From: [REDACTED]
Sent: 05 July 2018 14:57
To: Planning.Responses
Subject: A/81/18/RES Quiet Waters Roundstone Lane Angmering BN16 4AX

Our Ref: NW/ARU/17/14C

RE Quiet Waters Roundstone Lane Angmering BN16 4AX

Thank you for your correspondence of 15th June 2018, advising me of an Approval of reserved matters following outline consent A/132/17/OUT for appearance, landscaping, layout & scale for demolition of existing dwelling & the erection of 30 No. dwellings. This application is a Departure from the Development Plan and for which you seek advice from a crime prevention viewpoint.

1800mm High Close Boarded Fence

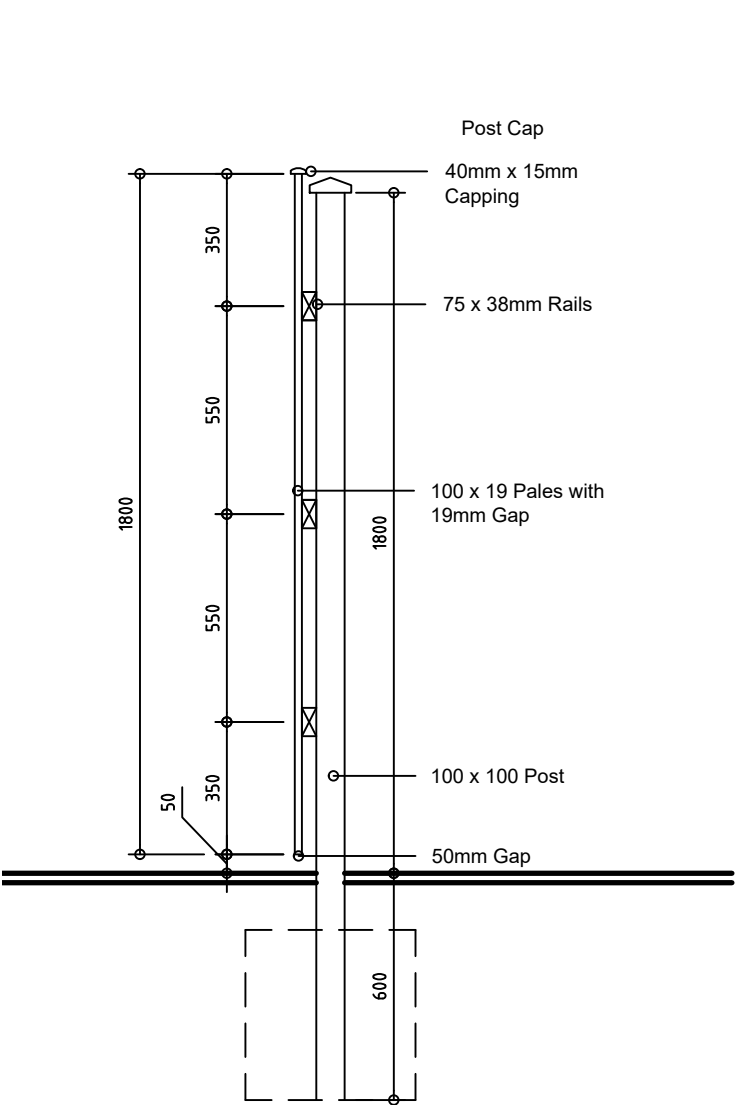
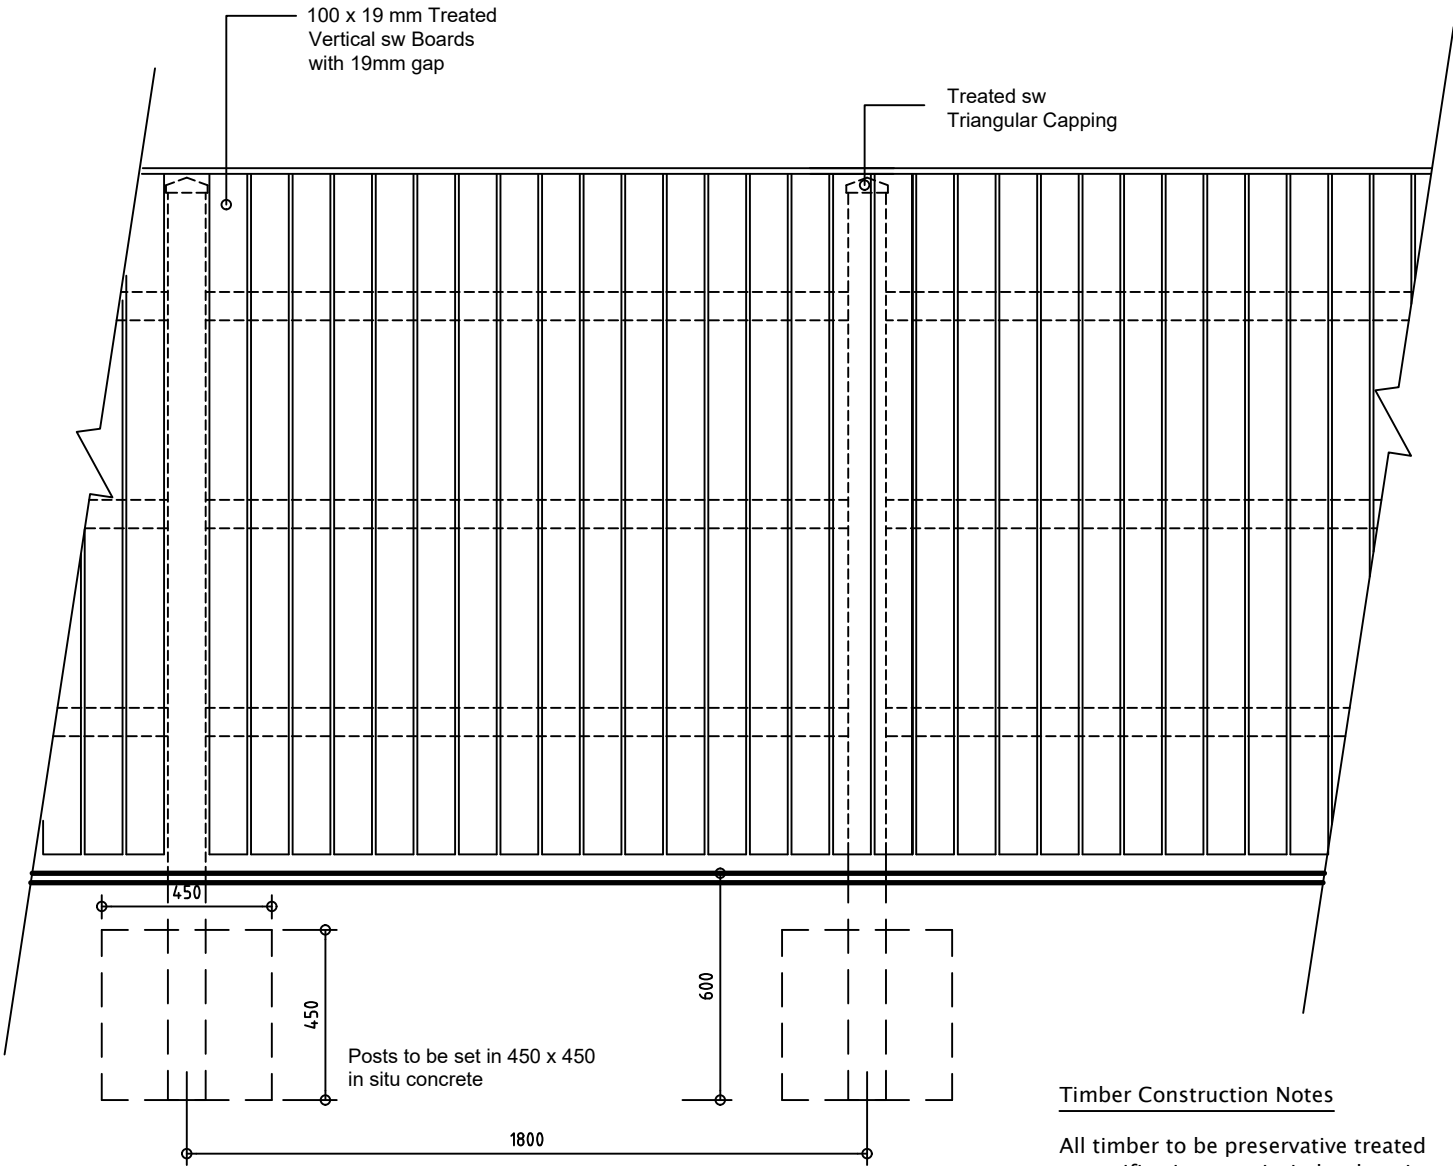
I would recommend that where circumstances allow, gates to the rear gardens of each property should be located at the front building line, as this provides better casual observation and acts as a deterrent for attempts to gain unauthorised access to the rear of the building. I would also recommend that the gates have controlled access and can be locked from both sides as this is more convenient and encourages relocking after use, helping prevent unauthorised access to the back of the property. Gates should be the same height as the adjoining fence.
